ENVIRONMENT PROTECTION AUTHORITY

I refer to the Project Application, Environmental Assessment (EA) and accompanying information provided for the proposed Tomingley Gold Project (ref 10_0155) received by the Environment Protection Authority (EPA) on 11 November 2011.

The EPA has reviewed the information in the EA and has determined that it is able to support the proposal subject to the Department of Planning (DoP) seeking the important amendments to the draft Statement of Commitments, identified in **Attachment A** and subject to the proponent addressing the information requirements outlined below and in **Attachment B**. **Attachment B** also contains the EPA's assessment of the proposal, including justification for the amendments and request for additional information.

Figure 11
APPROVED BIODIVERSITY
OFFSET STRATEGY

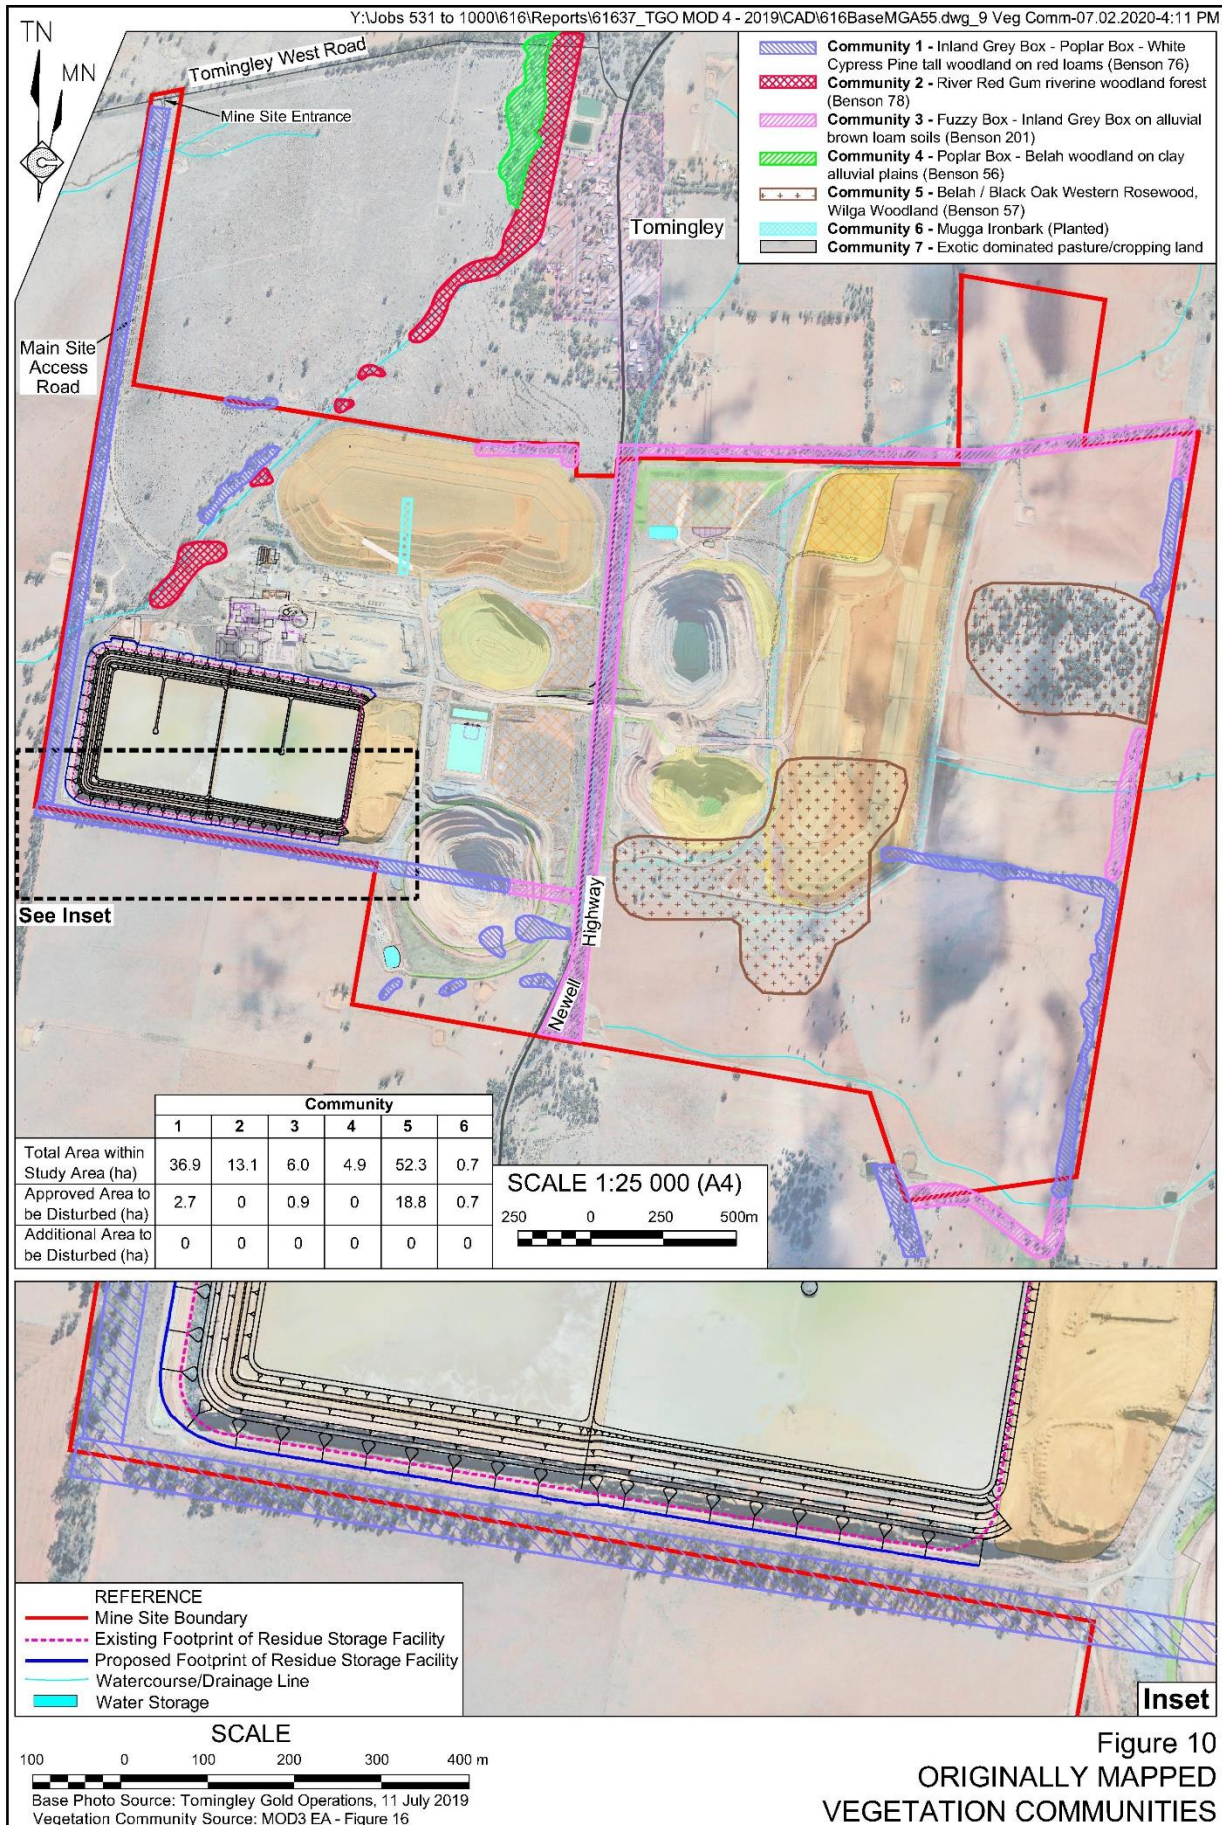
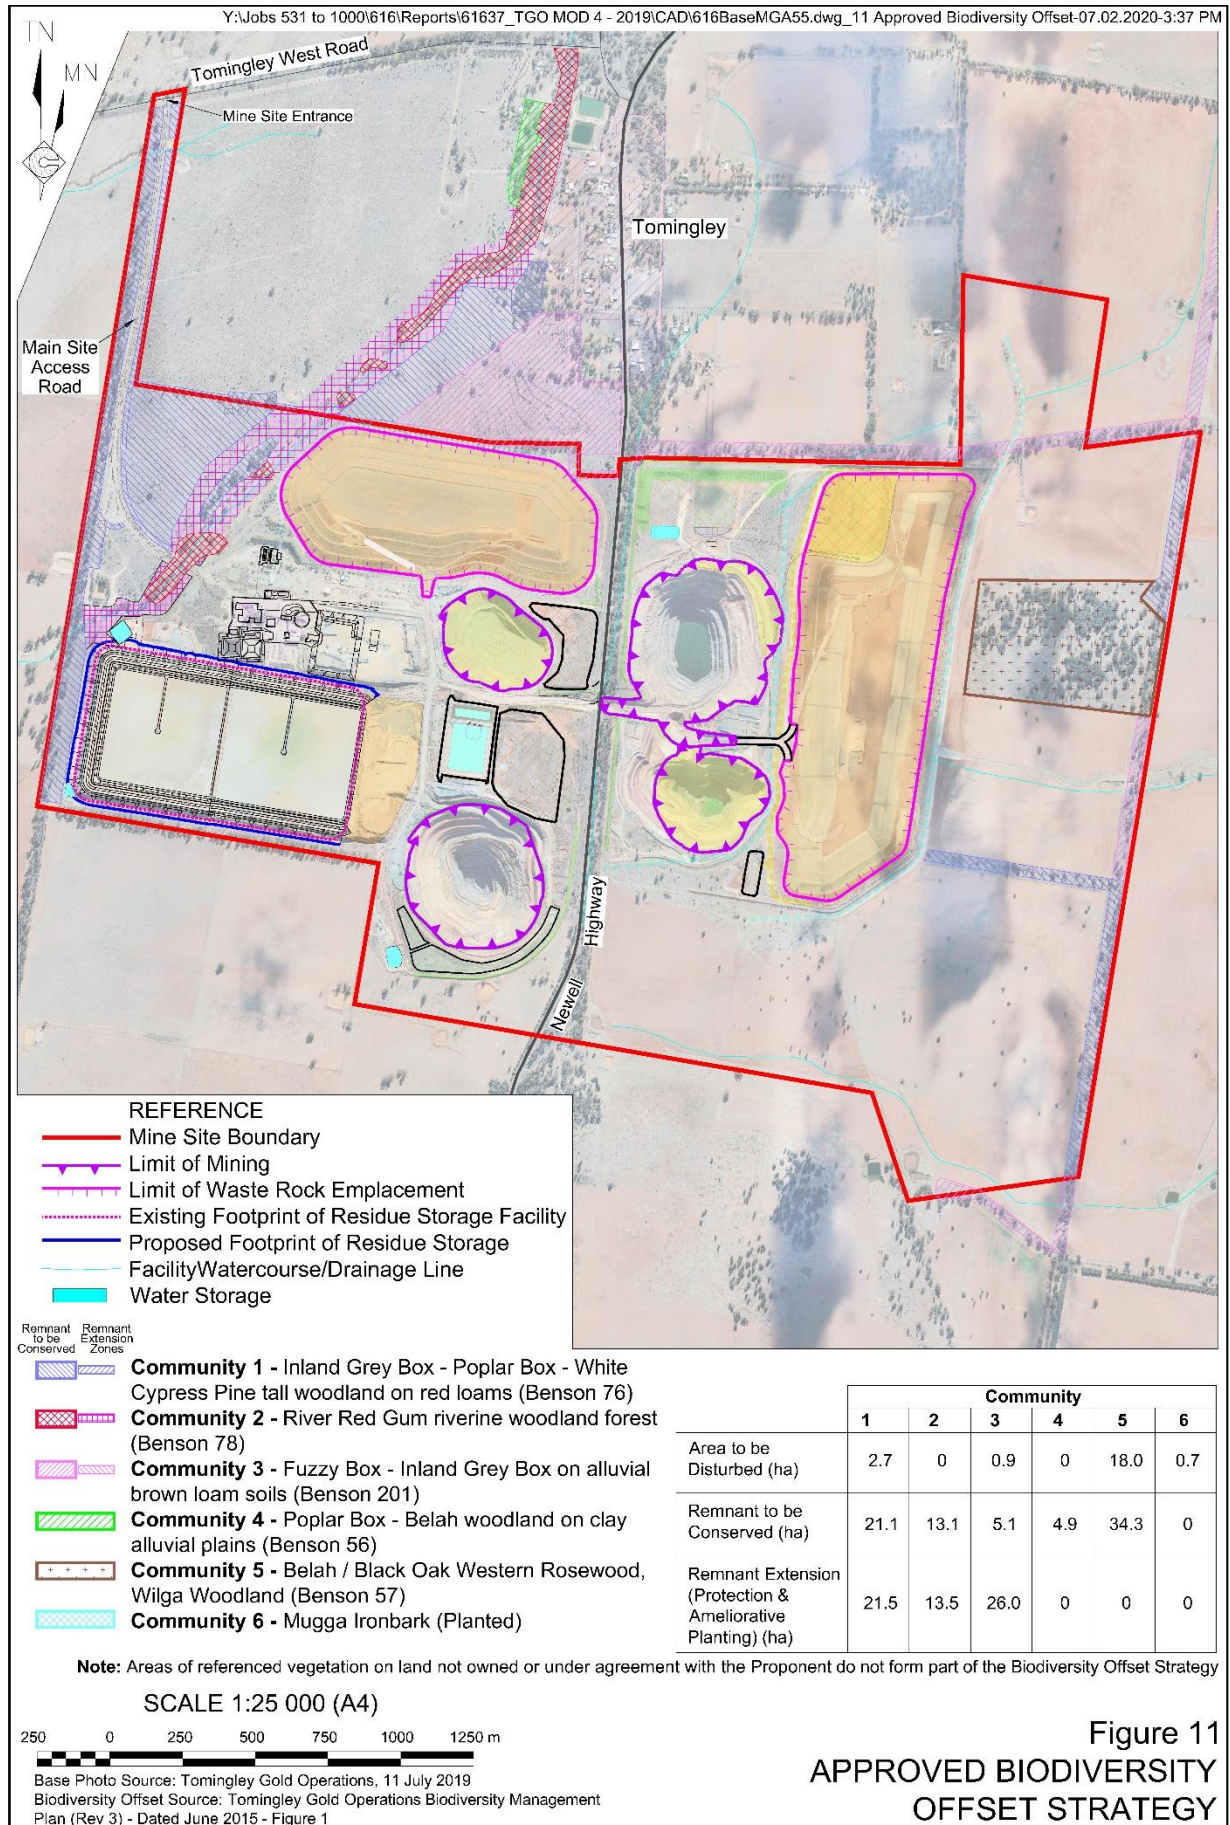
- o It appears that a portion of the proposed offset may overlap with the proposed water pipeline, proposed transmission line relocation, proposed optic fibre cable relocation and amenity bund(s). The EA does not specifically clarify these impacts in relation to the offset.

- Figures A10.1 and A10.2 in the BioBanking assessment include all native vegetation remnants that were mapped in the 'Study Area', including native vegetation which is stated elsewhere in the EA to be excluded from the BOS. It is not clear then whether the hectare figures provided in Table A10.3 for 'Total Area within the Study Area' (and subsequent offset area estimates) takes into account the exclusion of some remnants from the offset (there also appears to be a mistake in this table where 4.9ha of Poplar Box – Belah Woodland is listed as being impacted when elsewhere it is identified as not being impacted). It is important that the issue of what has been included in the 'Study Area' is clarified, so that it is clear that the BBAM has not been applied to areas which will not actually be included in the BOS.

It would be clearer if the EA contained a figure which only includes those mapped areas that will form part of the offset, and confirms which hectare estimates apply to actual BOS versus the wider Study Area. This map should also clearly indicate the location of the offset in relation to the location of all infrastructure and areas of disturbance.

- **Clarify with the proponent the exact location of all infrastructure in relation to the proposed offset (including proposed amenity bunds and relocated powerlines and optic fibre cables that are not included on the offset maps) and determine whether these impact the proposed offset.**

- **Require the proponent to commit to a clearly defined BOS, which includes clear map of the specific areas to be included within the offset, excluding other remnant vegetation.**
